Our Ref: 2026/036276

Council Comments on Response to Submissions - SSD-91496958 - 159-167 Darley Street West, Mona Vale

APPENDIX 1 - DETAILED COMMENTS FOR ADVICE ON EIS FOR SSD-91496958 NORTHERN BEACHES COUNCIL

Section

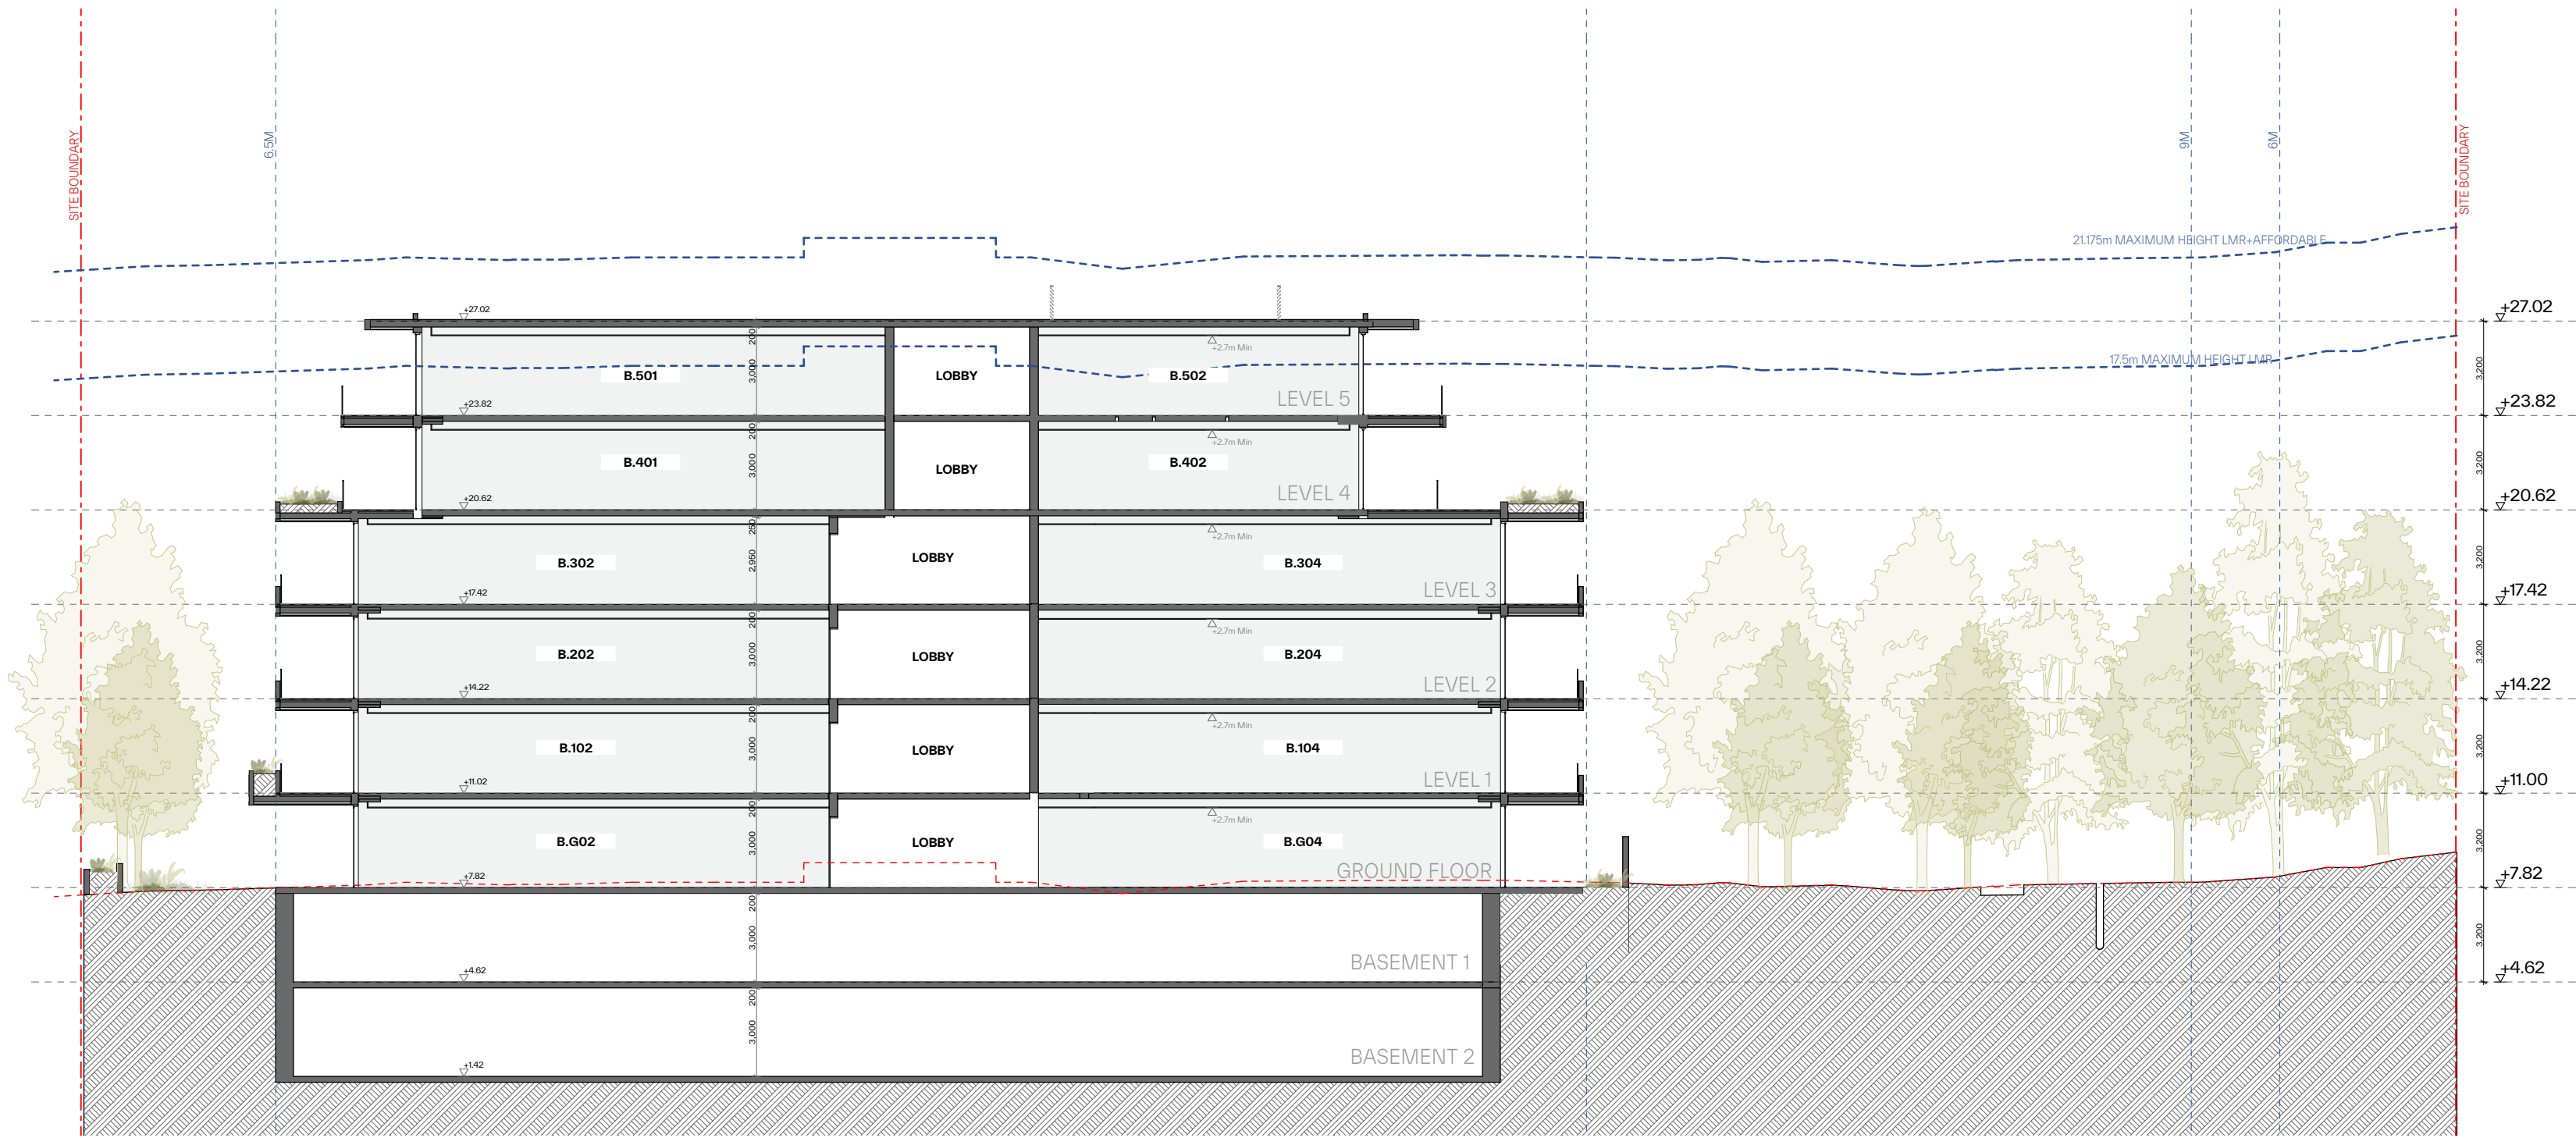
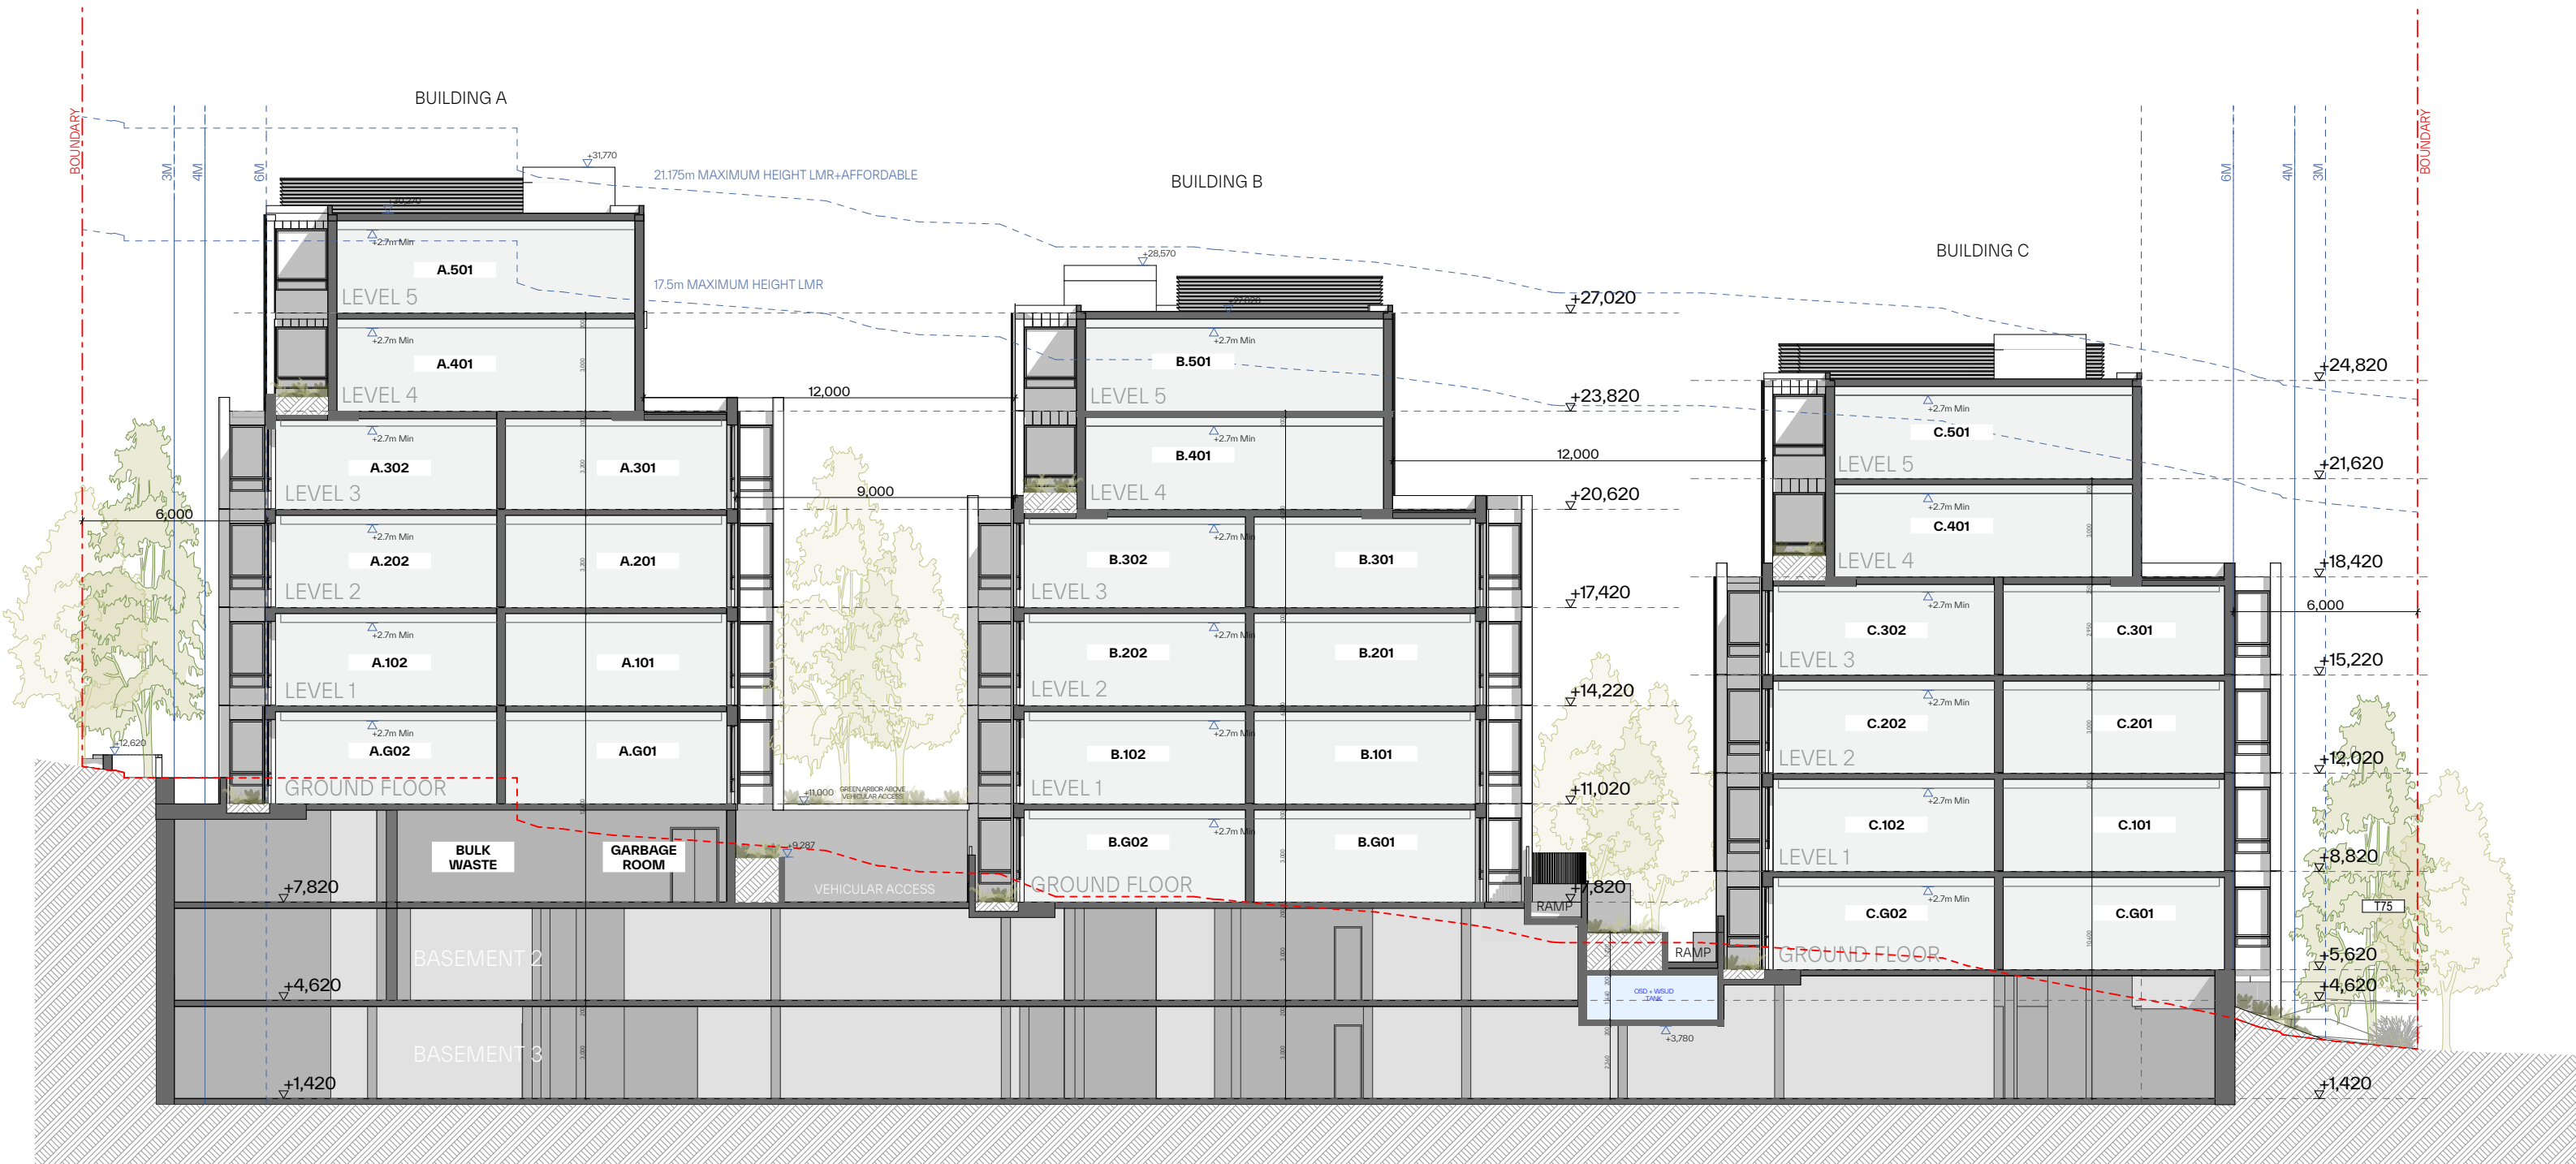
The proposed contributions are based on a building height of 21.175m. However, the maximum building height on the sections is approximately 22m.
